Application No: EP/2/21/HH
Site Address: 27A Sea Lane East Preston BN16 1NH
Description of works: Erection of front extension to create first floor balcony, erection of rear Juliet balcony, demolition of existing conservatory with changes to external materials and wall finishes.

Thank you for your internet representation made on 16th March 2021 which has been recorded as an objection with the comments as follows:

I am commenting on behalf of the East Preston and Kingston Preservation Society.

**Drawing Title:**  
Proposed Plans, Elevations, Roof Plan and Site Block Plan

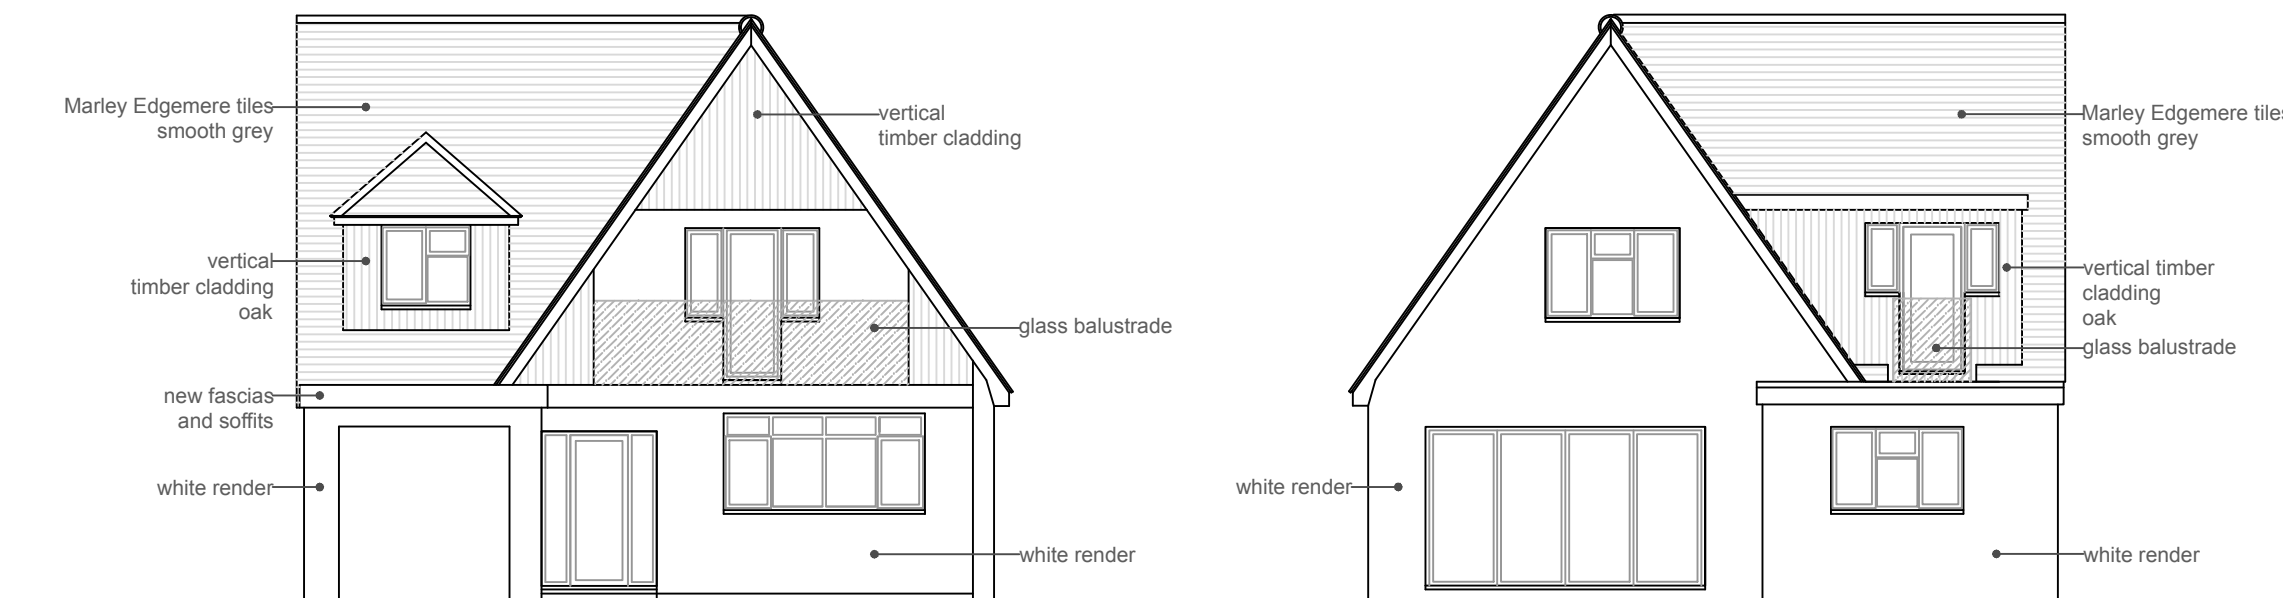
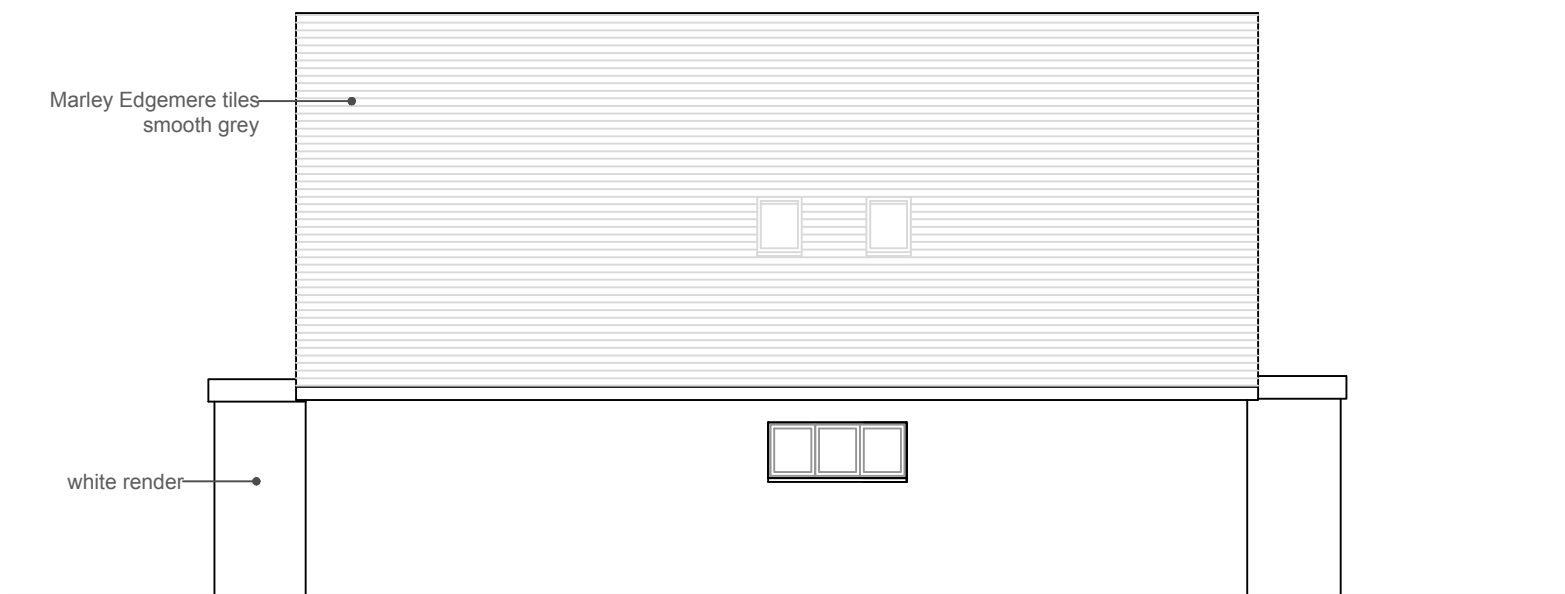
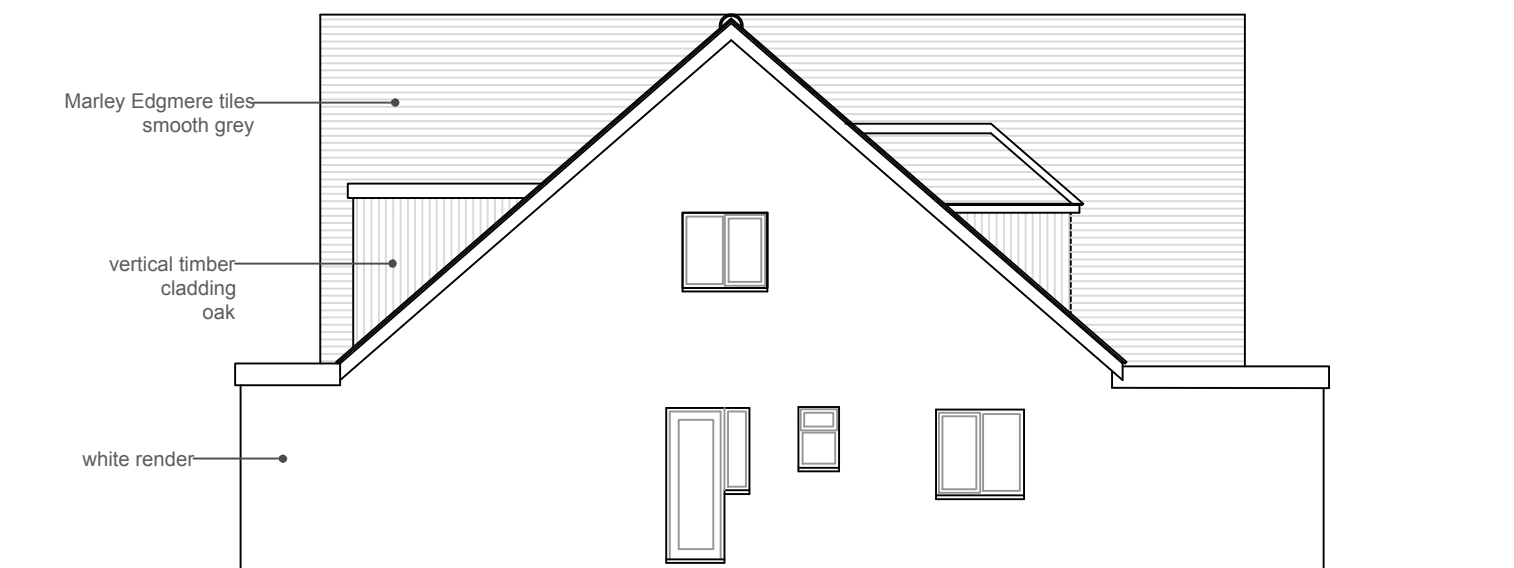
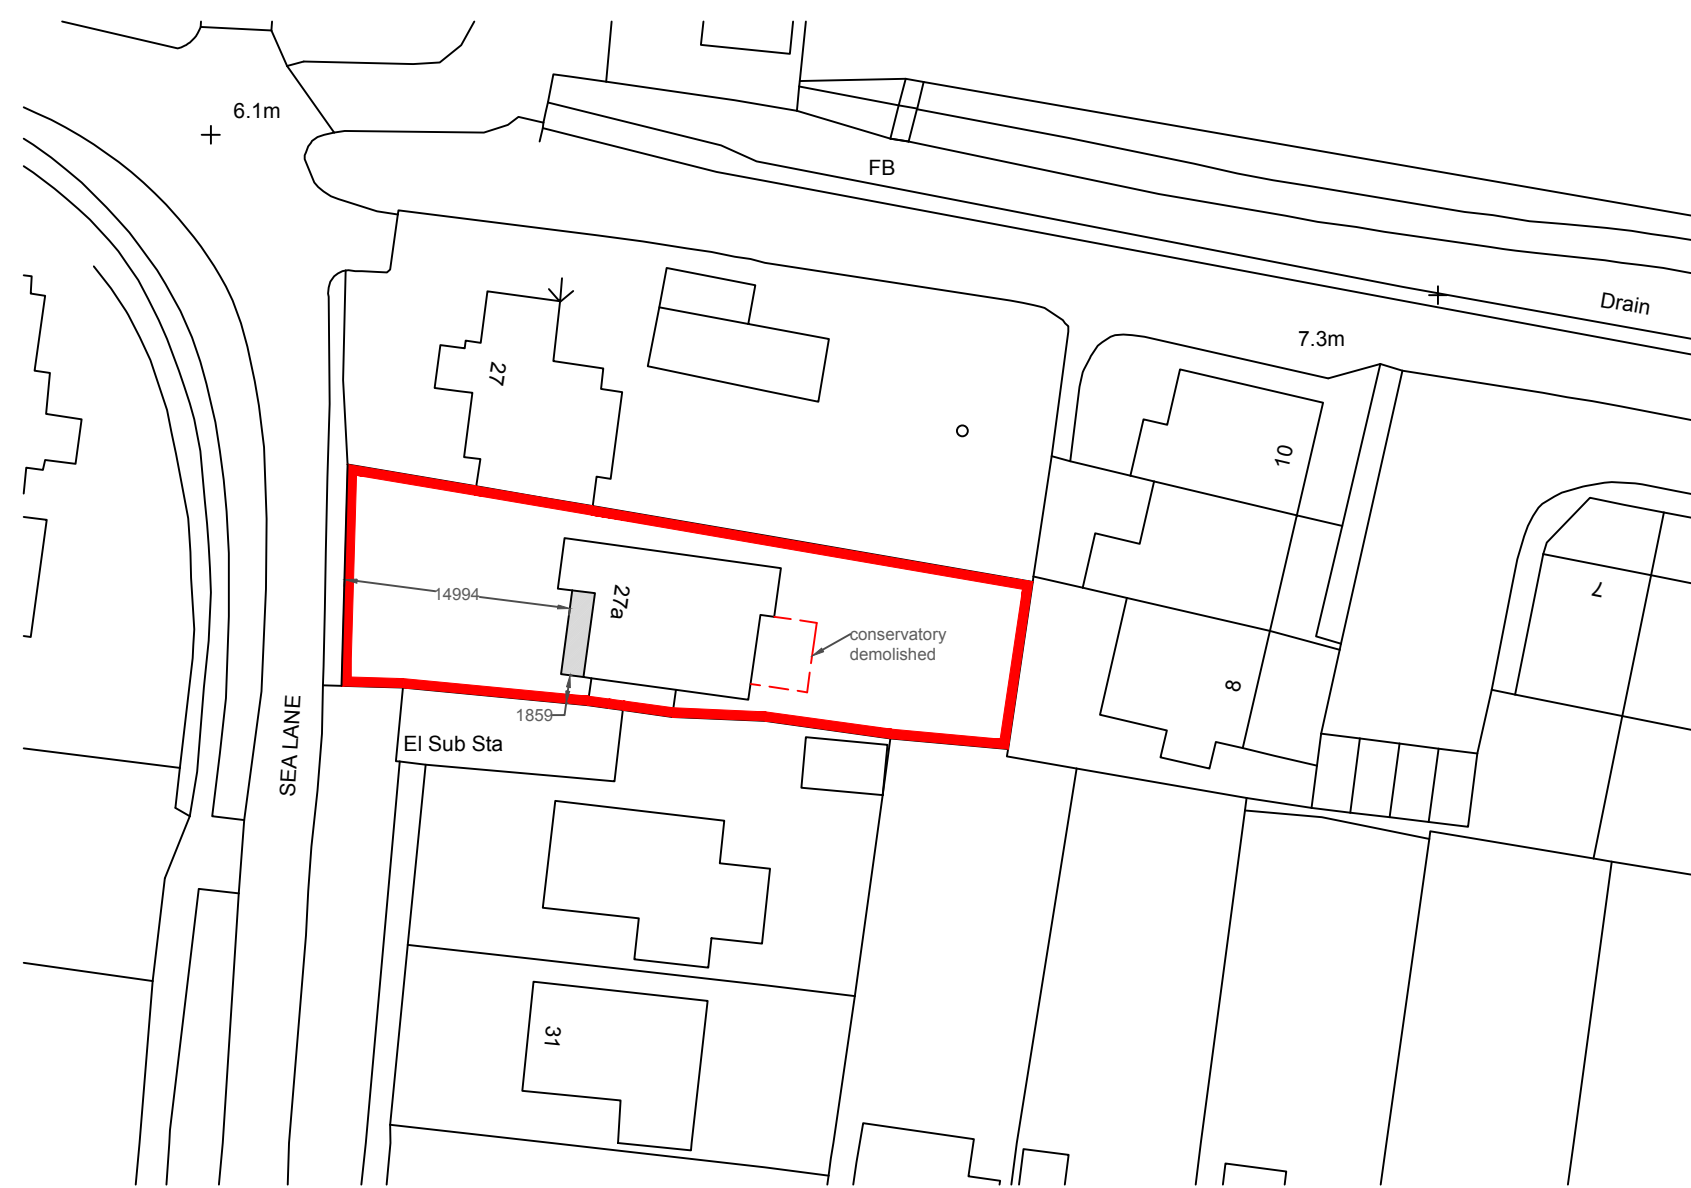
This comment is a supplement to our earlier letter. The amendment to the plans, removing the rear balcony, removes one of our objections to this application. However, our objection to the proposed roofing materials remains strong. Slate-effect tiles would not reflect the roofing material in any house in Sea Lane, in either colour or texture. Their use would therefore contravene both Policy D DM1 of the Local Plan and Policy 1 of the East Preston Neighbourhood Plan.
